**WELWYN HATFIELD BOROUGH COUNCIL
EXECUTIVE DIRECTOR - PLANNING, PUBLIC PROTECTION AND GOVERNANCE**

DELEGATED APPLICATION

Application No: 6/2017/2736/EM
Location: 159 Parkway Welwyn Garden City AL8 6JA
Proposal: Erection of single storey rear extension following demolition of existing outbuilding
Officer: Mrs Sarah Madyausiku

TITLE:
Proposed
Site plans, ground floor plan,
roof plan and elevations
DRAWN BY: CH
DATE: Oct 17
SCALE: varies @A1
PRO NUM: 17139
DRAWING NUM: 002
REV: -

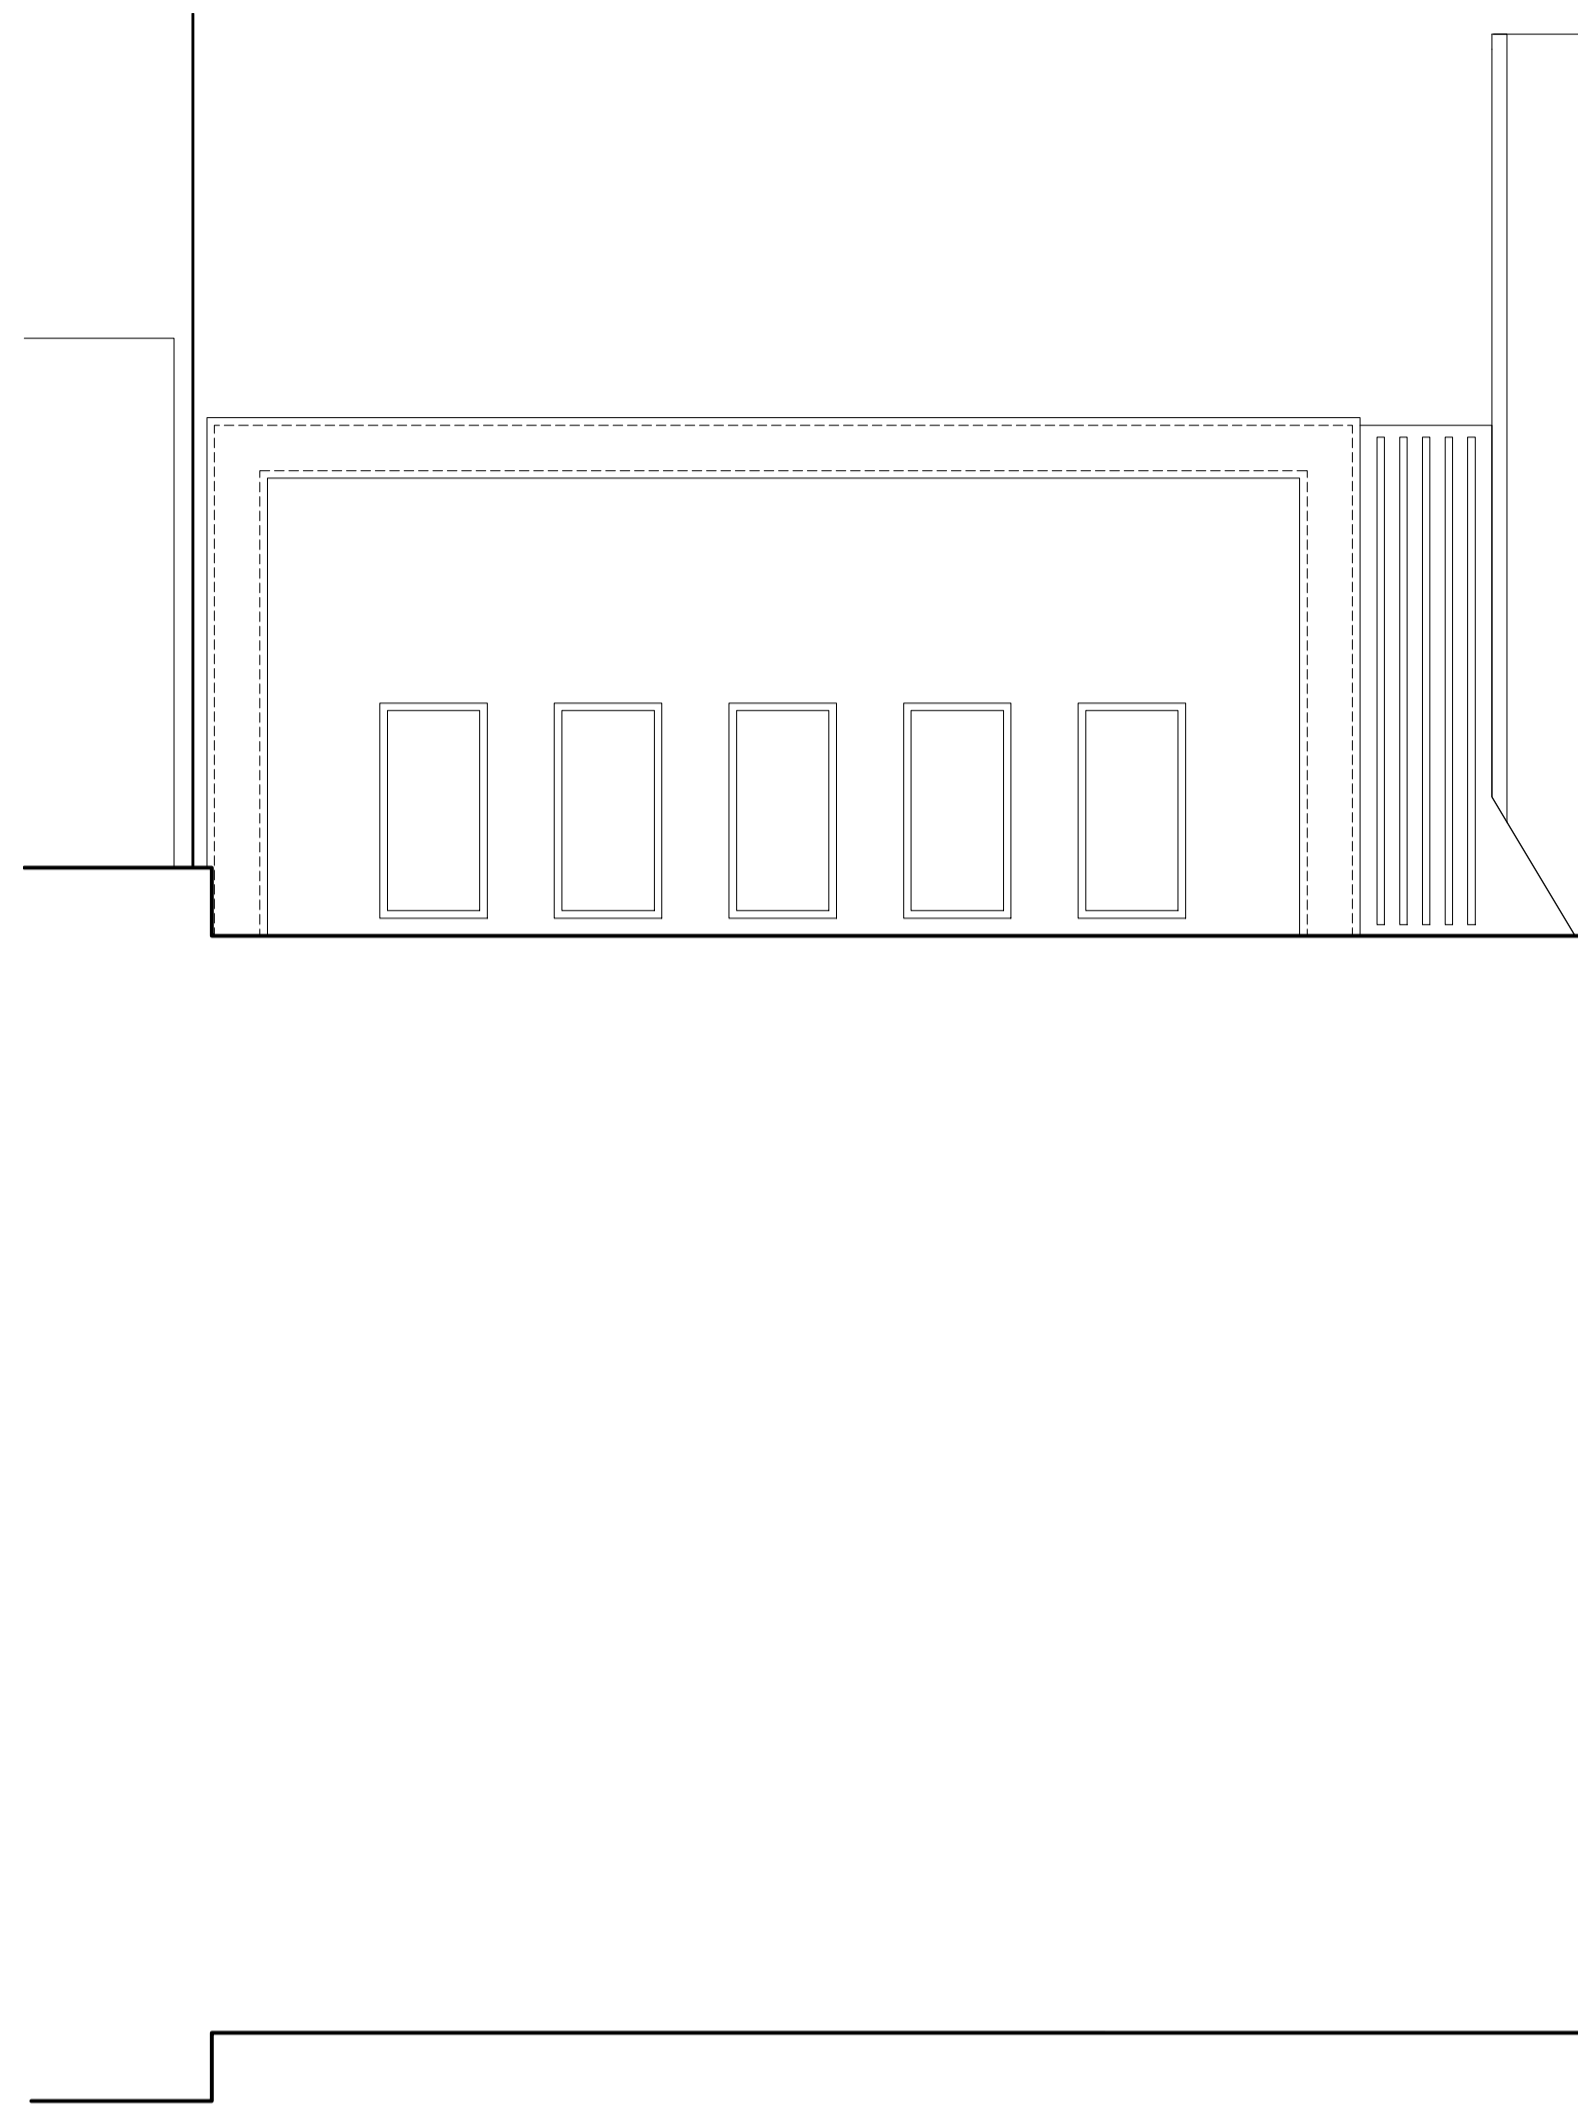
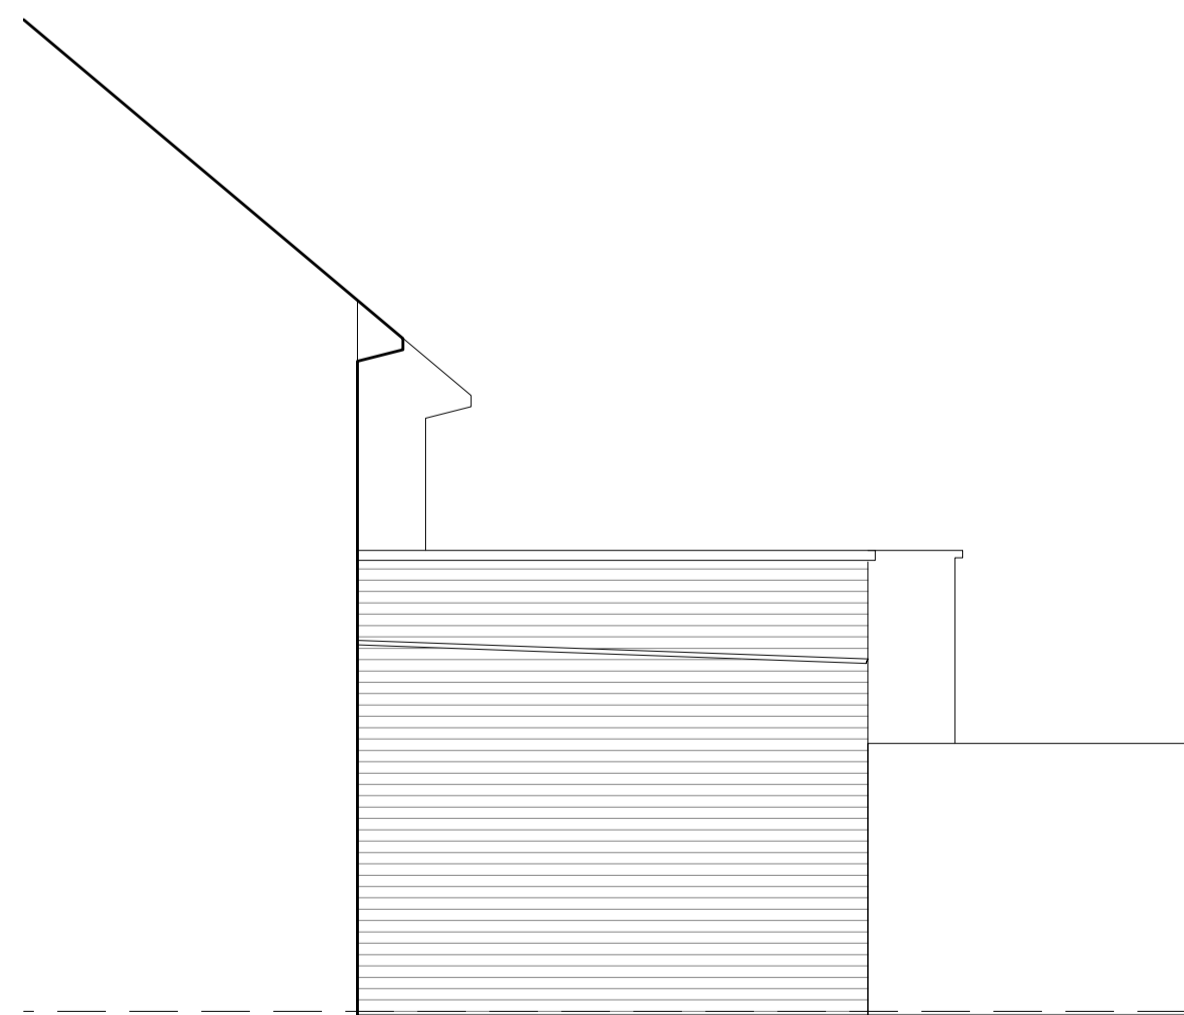
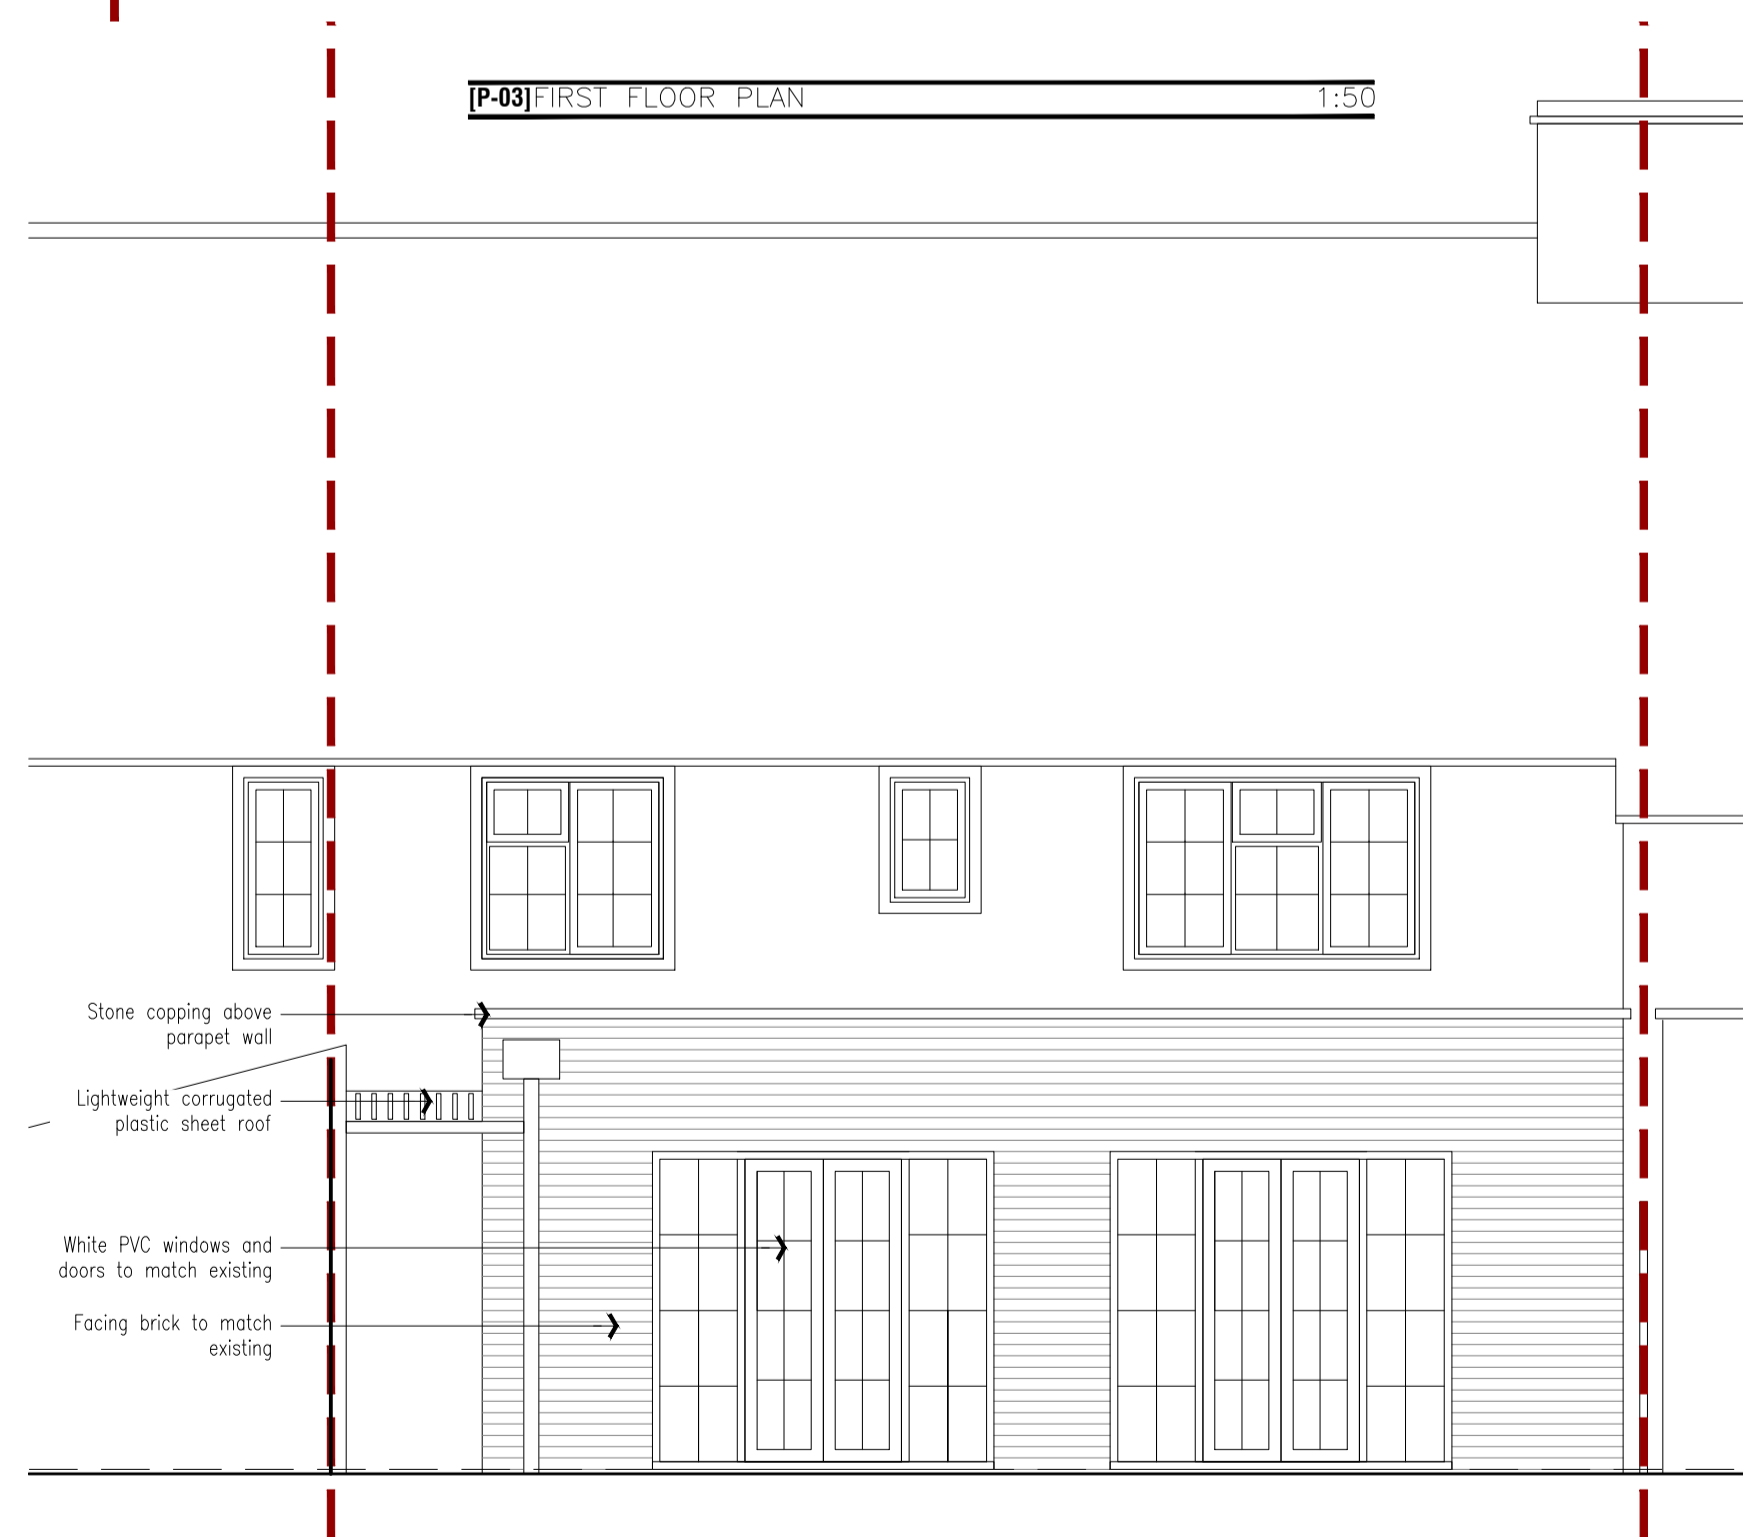
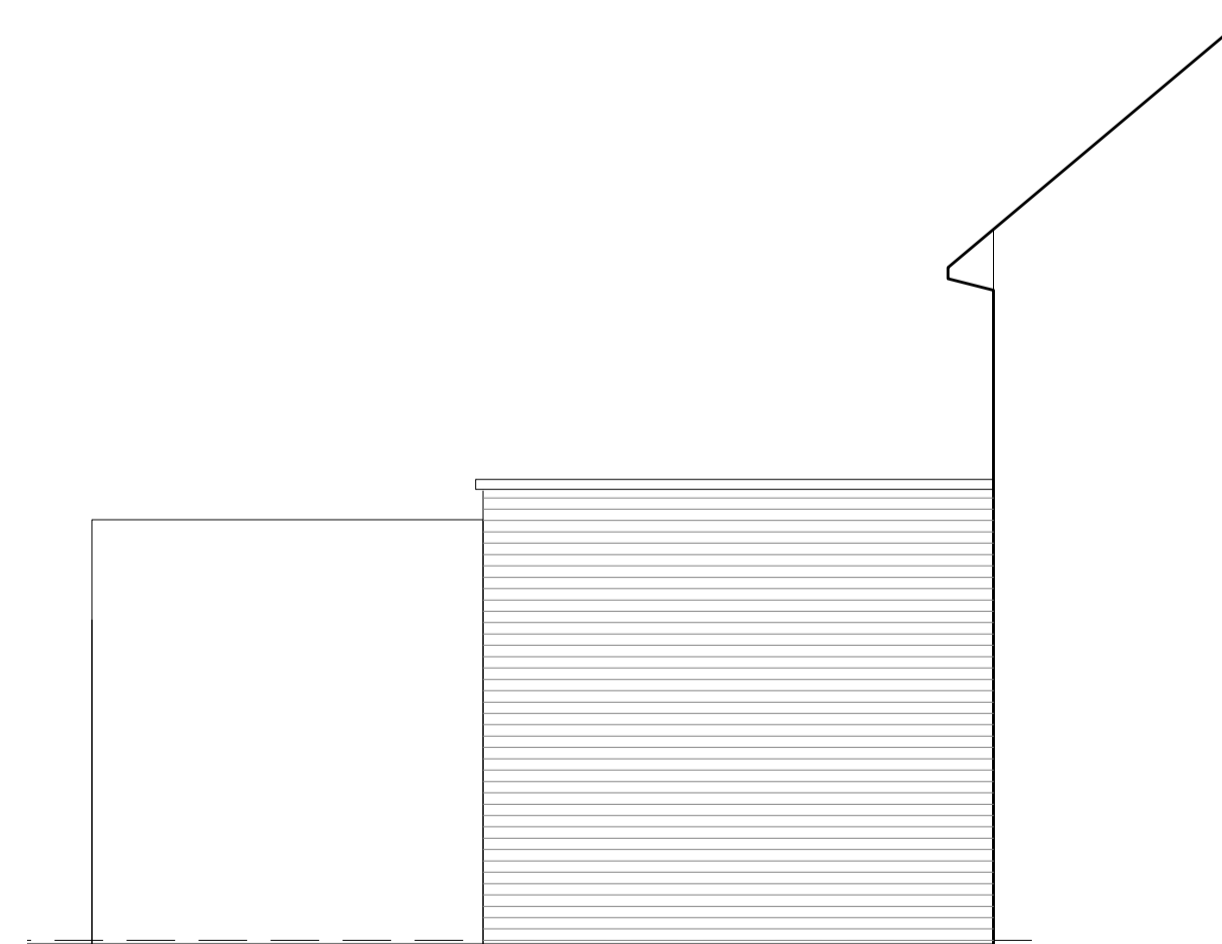
<input checked="" type="checkbox"/> Yes <input type="checkbox"/> No <input type="checkbox"/> N/A Comment (if required): The design approach of the proposed rear extension with its flat roof and limited height would be acceptable. A condition is recommended for the materials used in its construction to match those of the main house.			
Does the development minimise impact on neighbours?			
<input checked="" type="checkbox"/> Yes <input type="checkbox"/> No <input type="checkbox"/> N/A

5. The brickwork, bonding, mortar, roof tiles, cladding and architectural detailing (including soffits, eaves, external pipe work and guttering) of the approved extension/alterations shall match that used in the existing dwelling.
